## CITY OF ALBUQUERQUE PLANNING DEPARTMENT May 22, 2013 DRB Comments

PROJECT # 1007362

**APPLICATION # 13-70554**

RE: Tract A-1-A, Block 22, Bellhaven Addition

AS-101

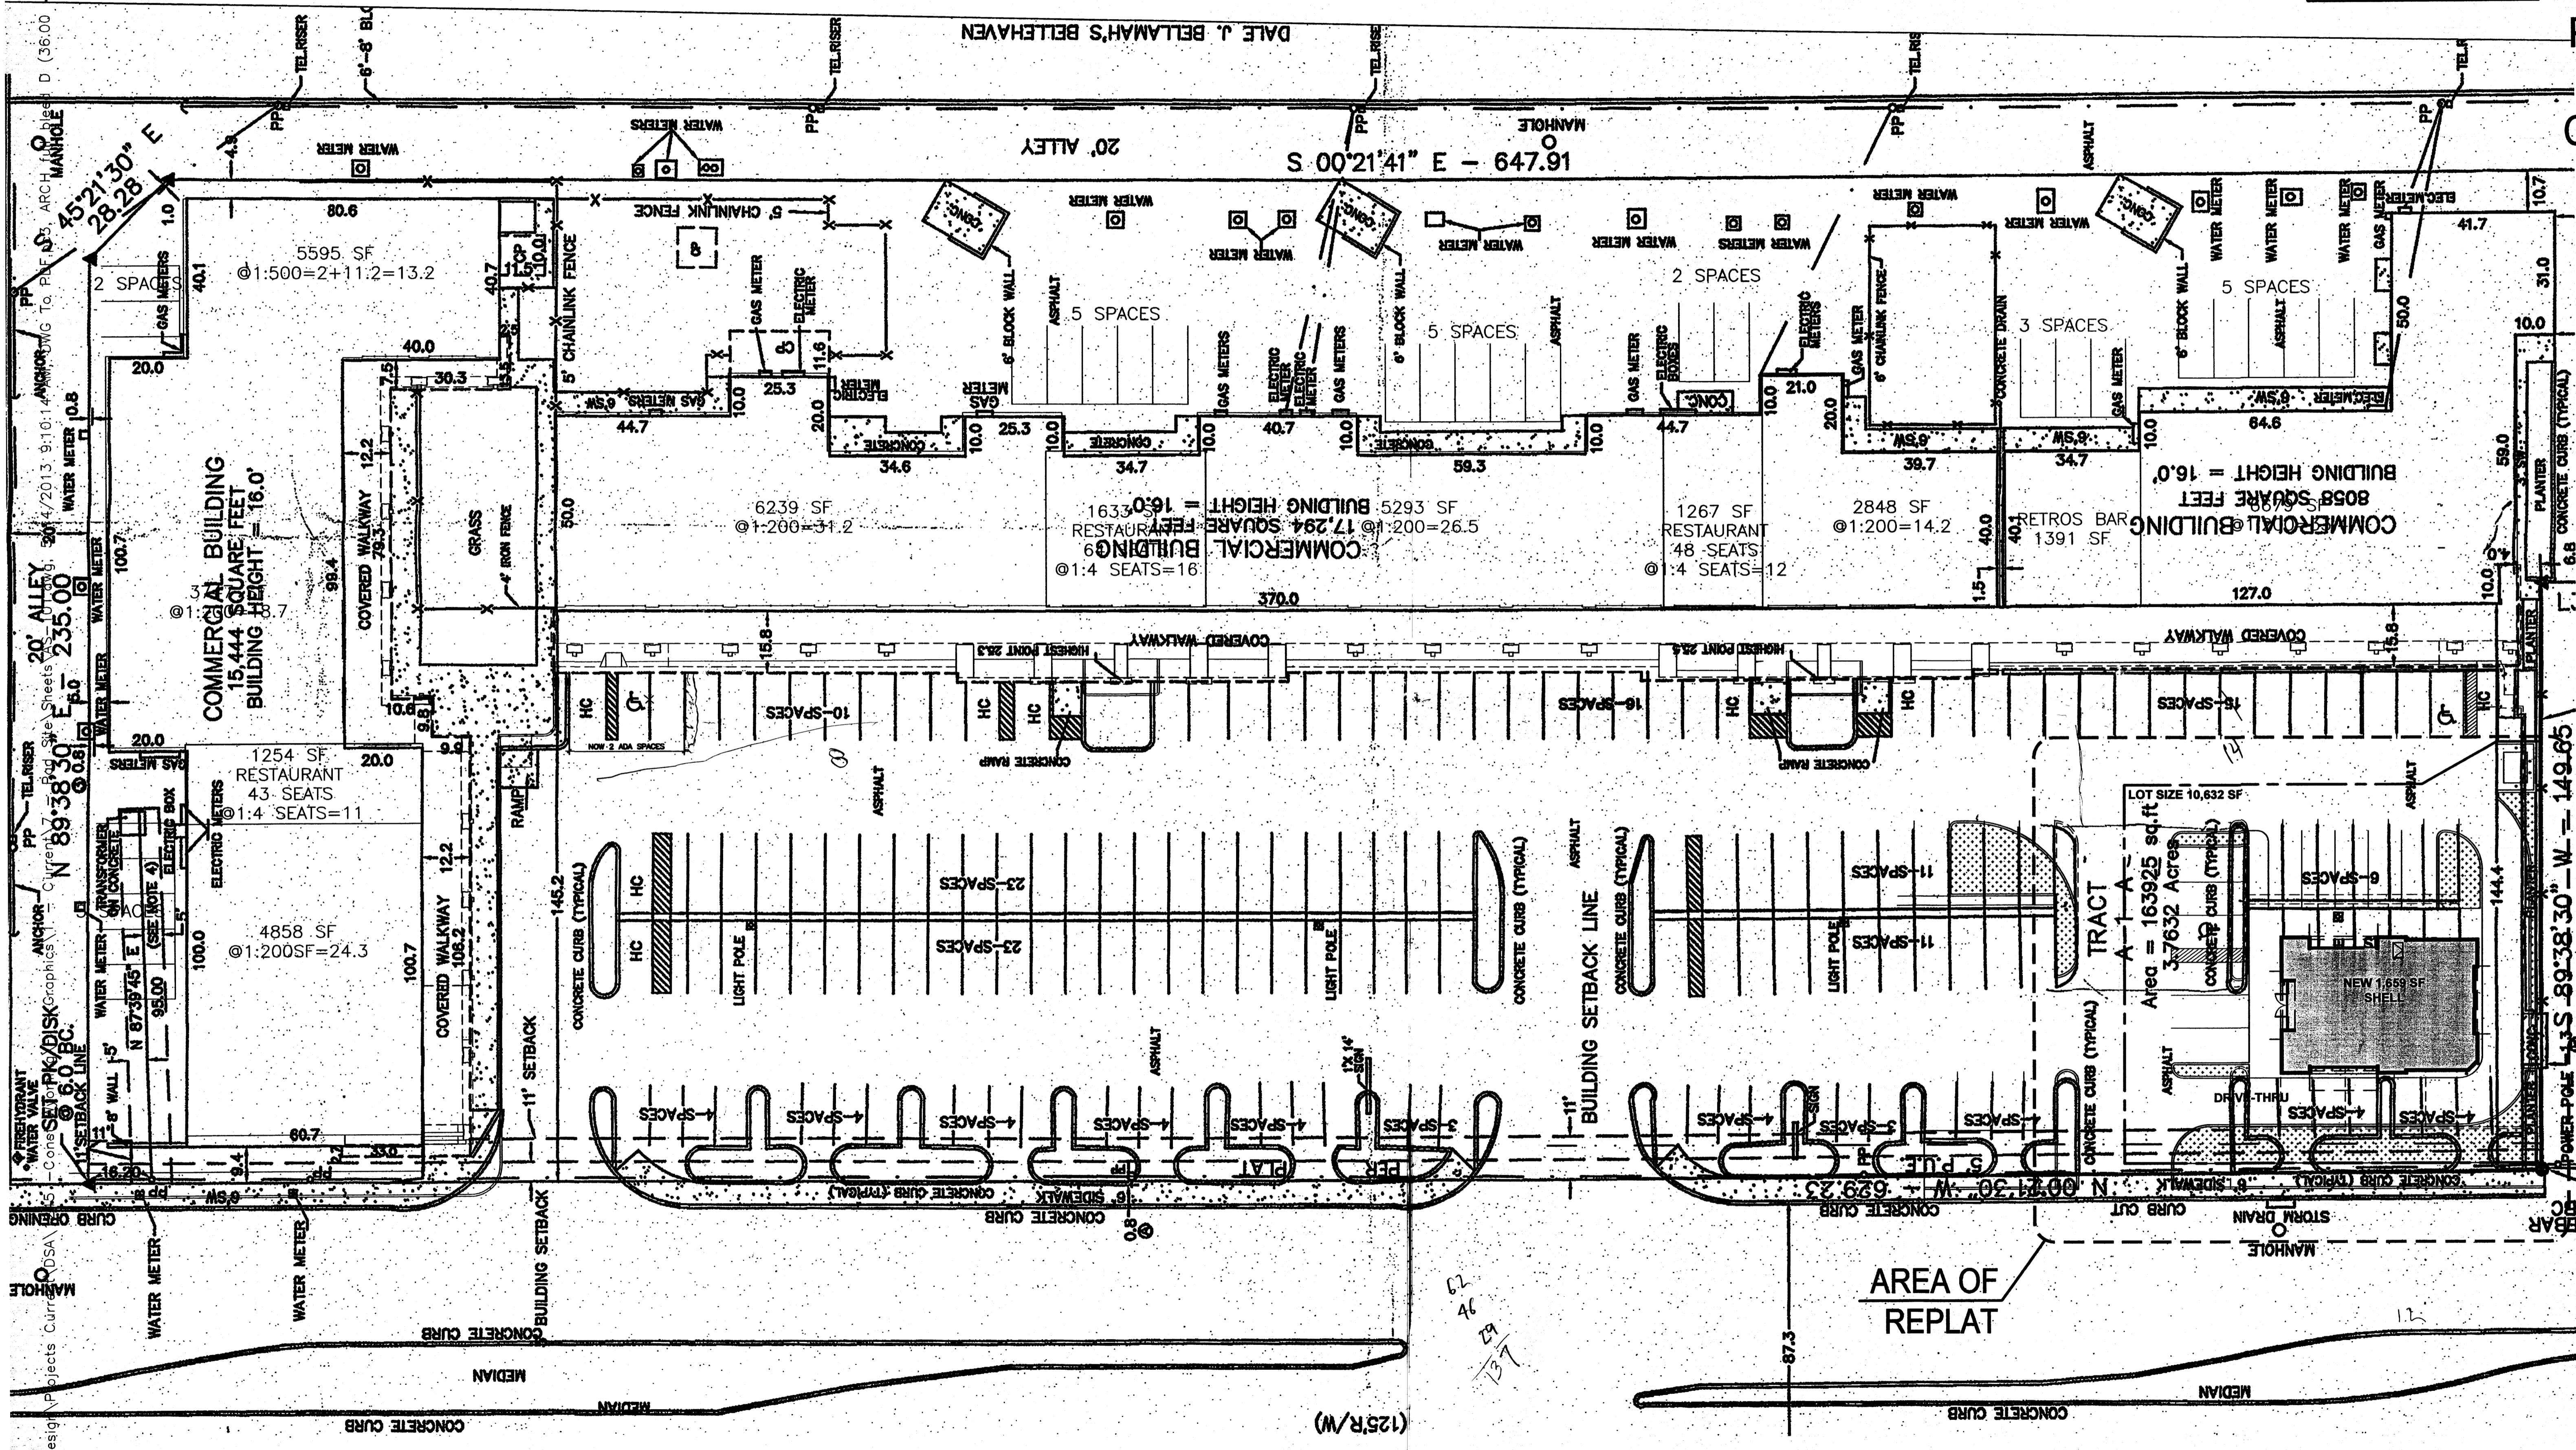
It may be difficult to obtain a shared parking agreement to meet required on-site parking based on C-2 zoning; such agreements generally require a mix of uses, such as residential with commercial.
